**KIRKLEES METROPOLITAN COUNCIL
INVESTMENT & REGENERATION SERVICE**

DELEGATED DECISION TO DETERMINE PLANNING APPLICATIONS

Reference No: 2020/62/90989/W
Site Address: 14, Edgerton Road, Edgerton, Huddersfield, HD1 5RB
Description: Erection of dormers and alterations (within a Conservation Area)
Recommending Officer: Ellie Worth

DECISION - Refused

This drawing is copyright.

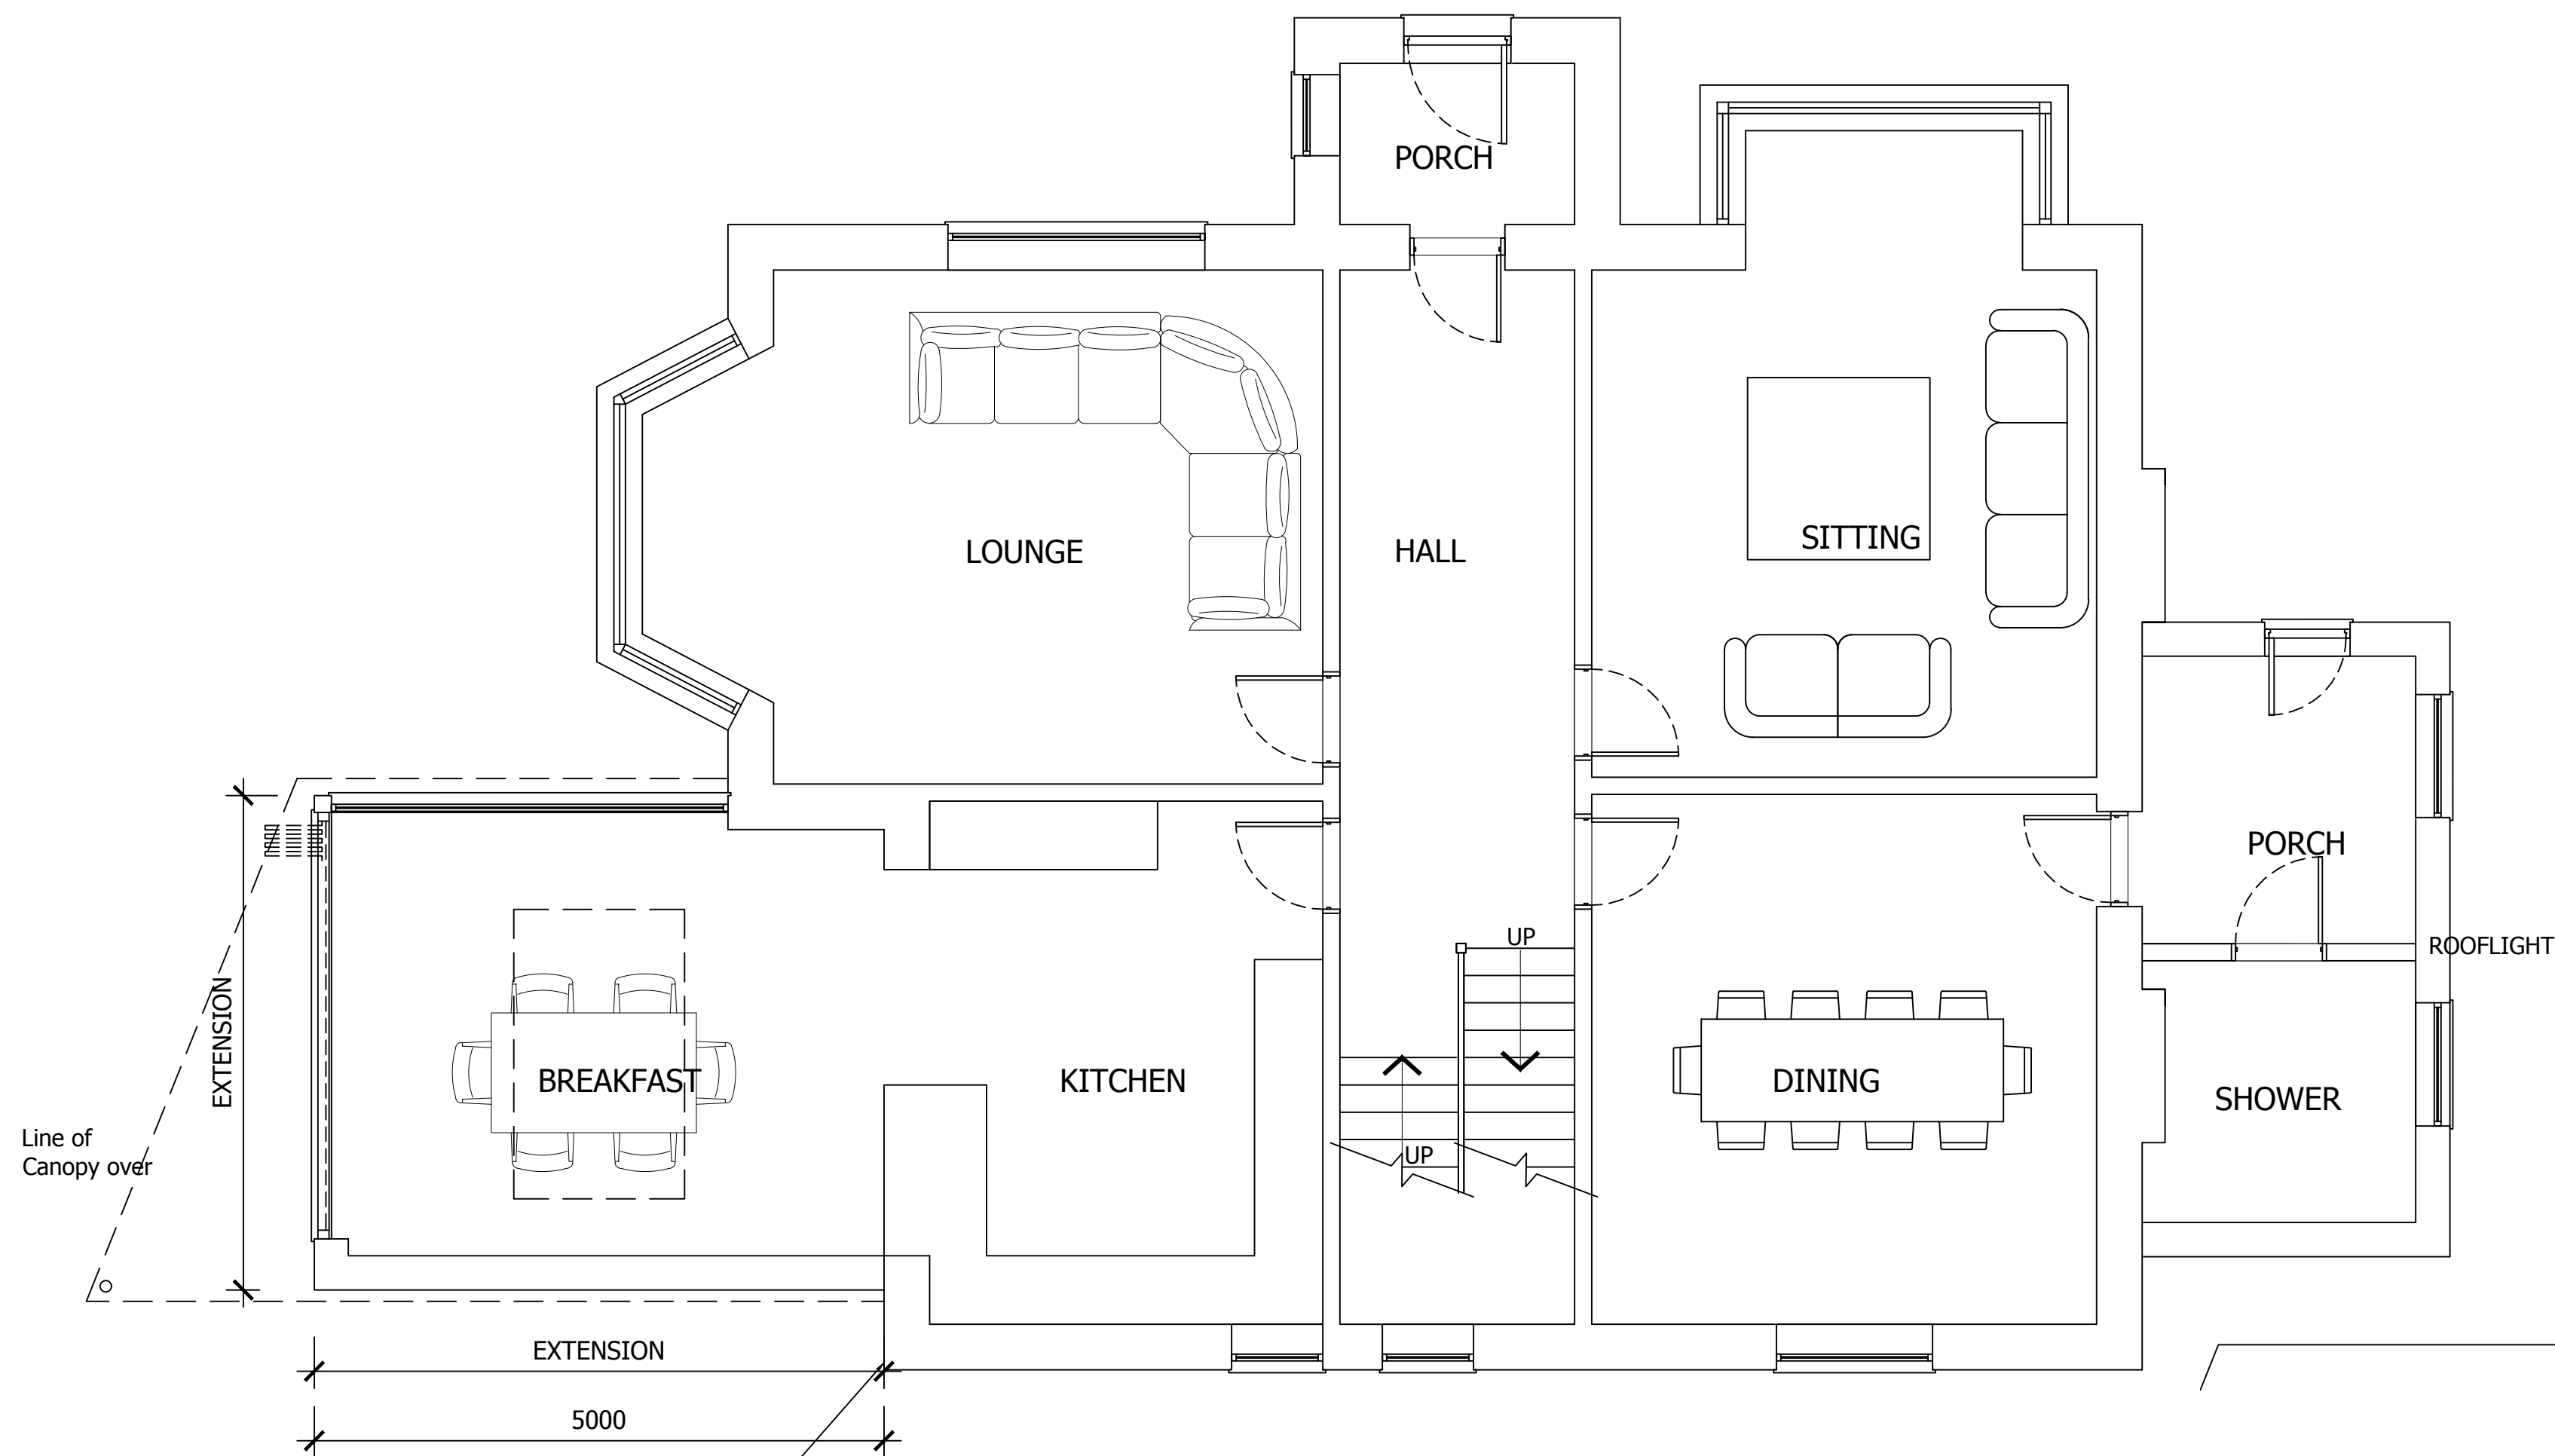
It is also noted that the lean to extension is still shown on the elevations plans. This is a discrepancy, as the agent has confirmed that the applicant is now only seeking permission for the dormers and roof lights.

Whilst significant amendments have been sought as part of this application, in order to remove both side extensions, concerns are still raised regarding the impact in which the flat roof dormer would have upon the character and appearance of Edgerton Conservation Area.

However, in this case, Officers have noted that dormer windows are not a common feature within the surrounding landscape, with the flat roof element appearing incongruous due to its size and scale. This has been proposed based on function rather than form and would be widely viewed from Edgerton Road. As such, the design of the dormer windows can not be supported.

Two dual pitched dormers would also be an addition to the development, however, on balance given their limited size and scale, any impact is not considered to be undue. This is due to the sympathetic design of these elements, in which would harmonise to an acceptable degree with the host property.

In this instance, KC Conservation and Design have been formally consulted, raising no objection to the roof lights, provided that these are conditioned as being of a 'Conservation' style. However, the flat-roofed dormer spanning the double pile roof, would be out of keeping of the area and therefore the development would cause moderate harm to the character and appearance of Edgerton Conservation Area. That harm would be less than substantial.

1. The proposed flat roof dormer by reason of its scale, spanning a large section of the roof of the host dwelling and flat roof design, would form an incongruous addition to the host dwelling, which would be widely viewed from Edgerton Road and the wider Edgerton Conservation Area. The proposal would therefore cause detrimental harm to the character and appearance of Edgerton Conservation Area and the setting of the surrounding Listed Buildings. This harm is considered to be less than substantial, however, as required by Paragraph 202 of the National Planning Policy Framework, great weight has been given to that harm in assessing the impact of the proposed development. Public benefits have not been demonstrated that would outweigh the harm caused in this case. The development would therefore be contrary to the Council's duties under the Planning (Listed Buildings and Conservation Areas) Act 1990, Policies LP24 and LP35 of the Kirklees Local Plan, the aims of the Councils House Extensions and Alterations SPD and Chapters 12 and 16 of the National Planning Policy Framework.
